Please upload below as planning correspondence for AL/23/20/HH

Proposed Rear Elevation

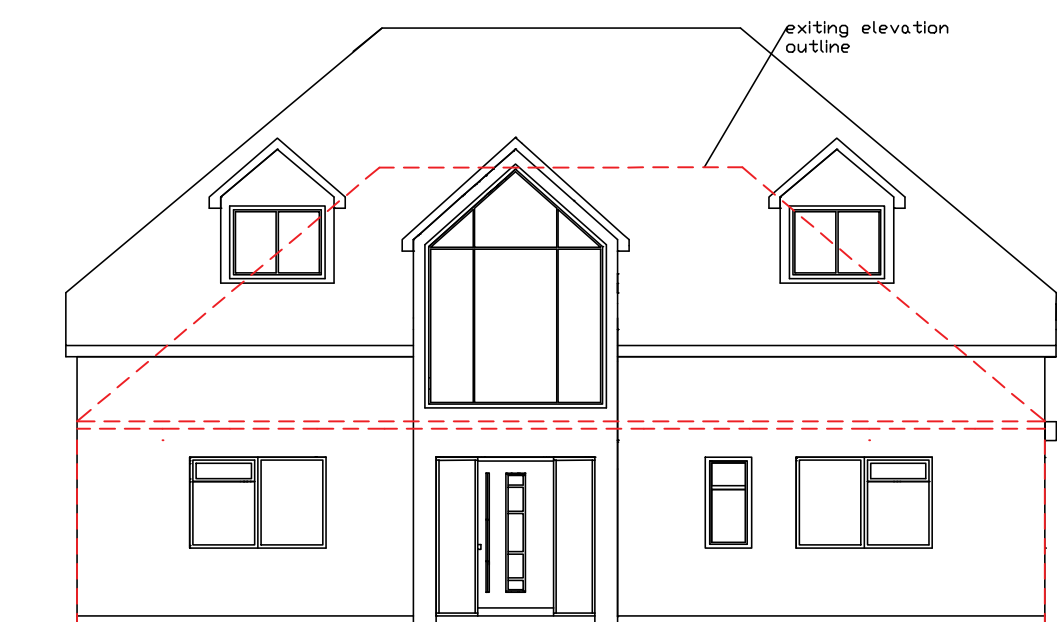
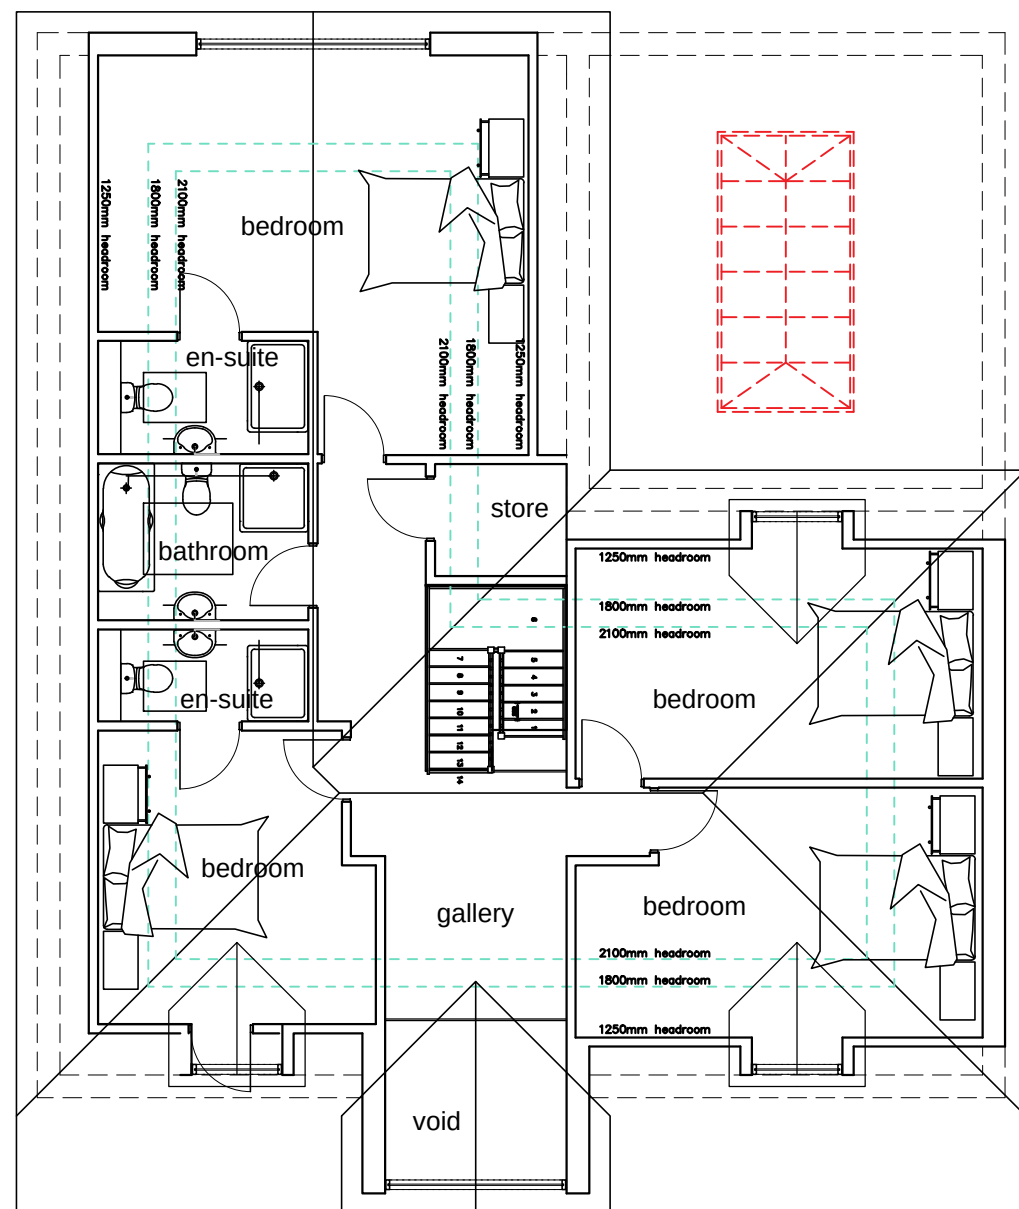
Mark has asked me to look into the concerns raised by the 'potential for overlooking from the bedroom facing to the rear above the single storey element'. And asked us to propose an alternate solution to overcome this issue.

Proposed Rear Elevation

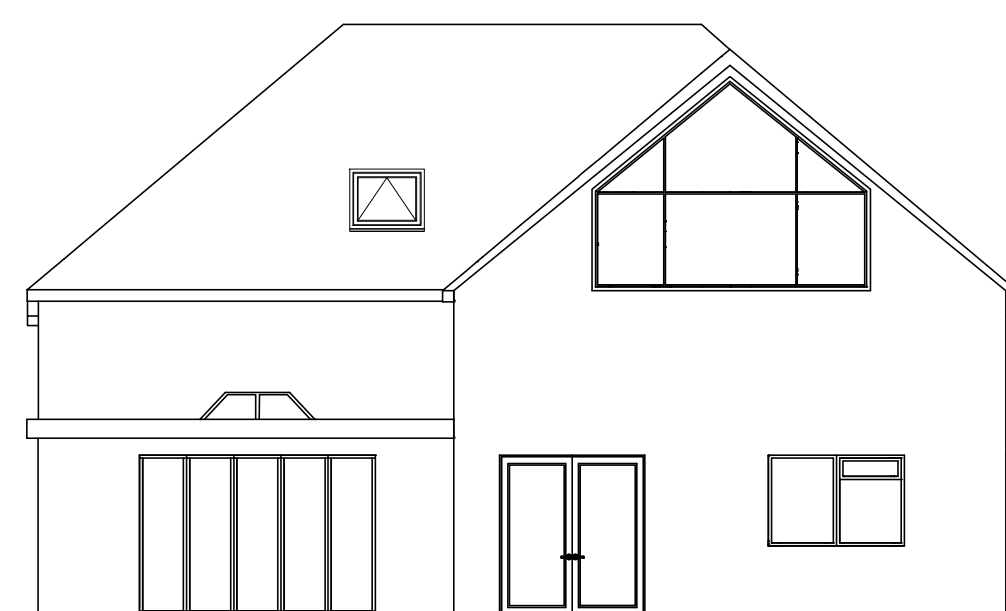
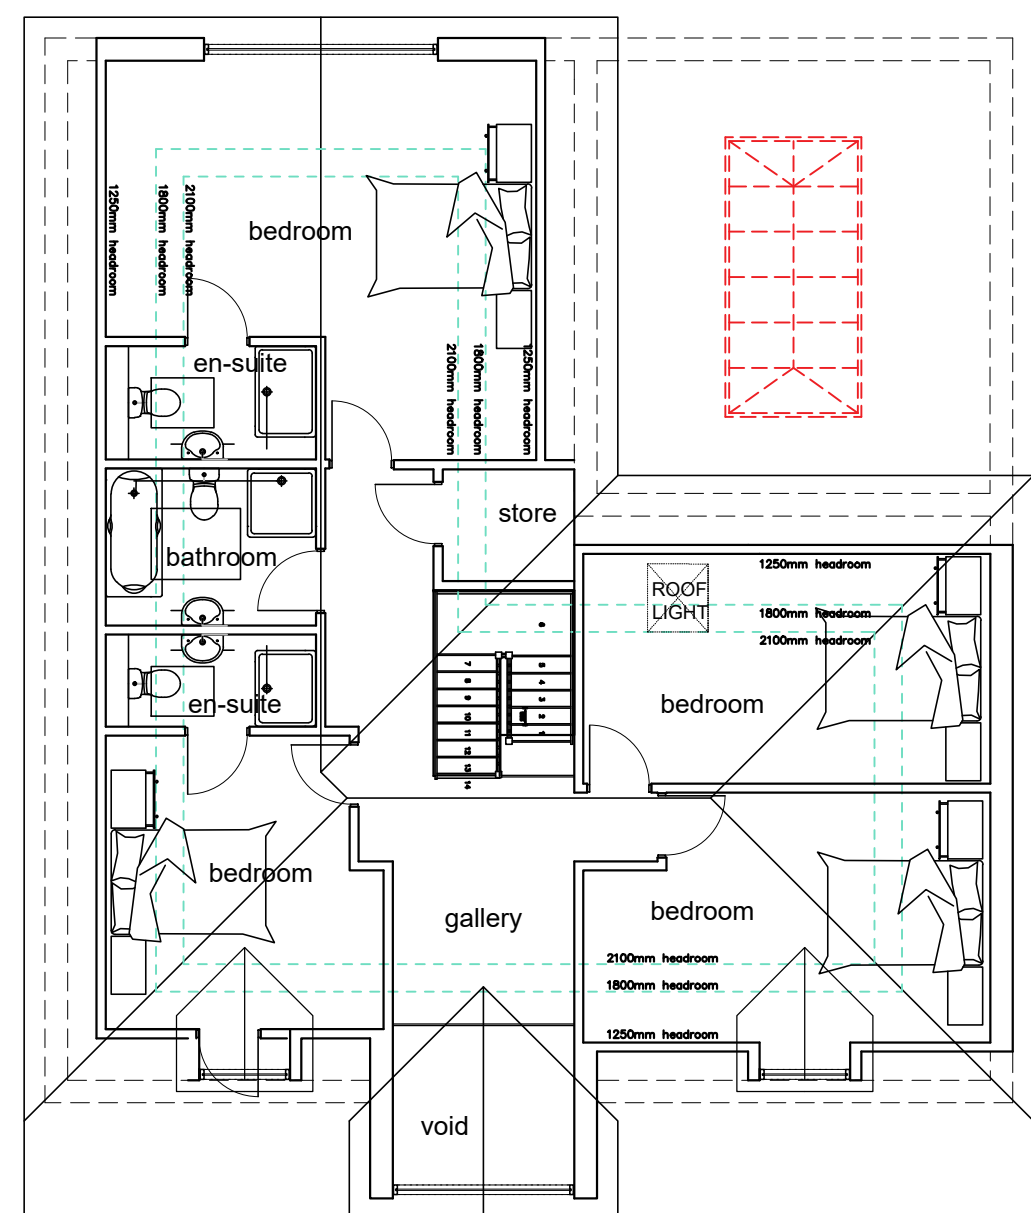
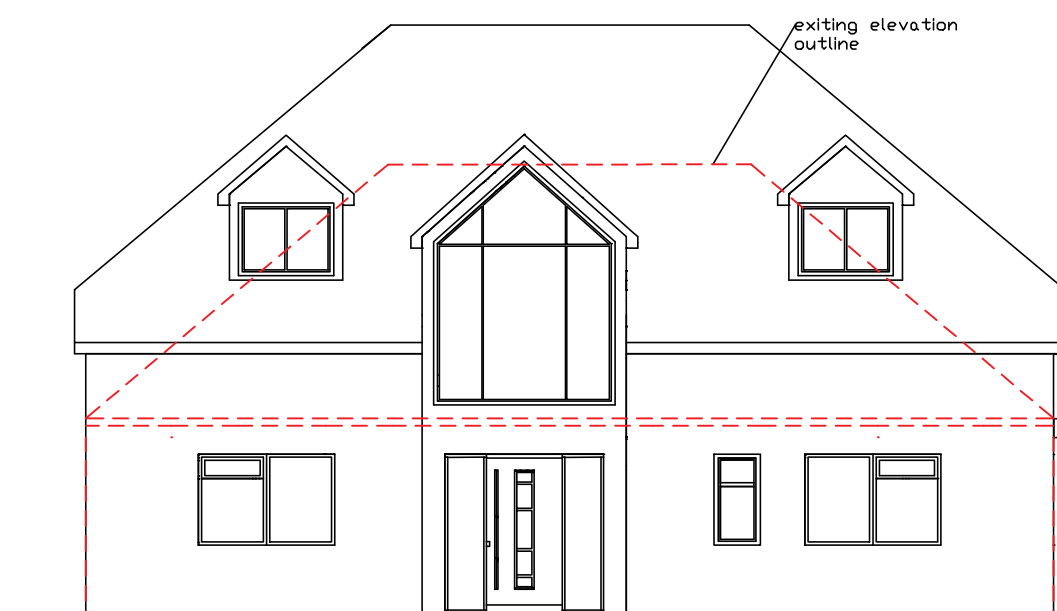
Having received the amended plan below, I believe this will limit adverse overlooking, with views the same as existing due to the current rooflight.

Overall the alterations to this proposal now seek to have a Velux style skylight in place of the originally proposed dormer, this has been shown in the revisions undertaken to drawing 8901-02A. we feel that this should minimize and significantly reduce any concern raised about overlooking.
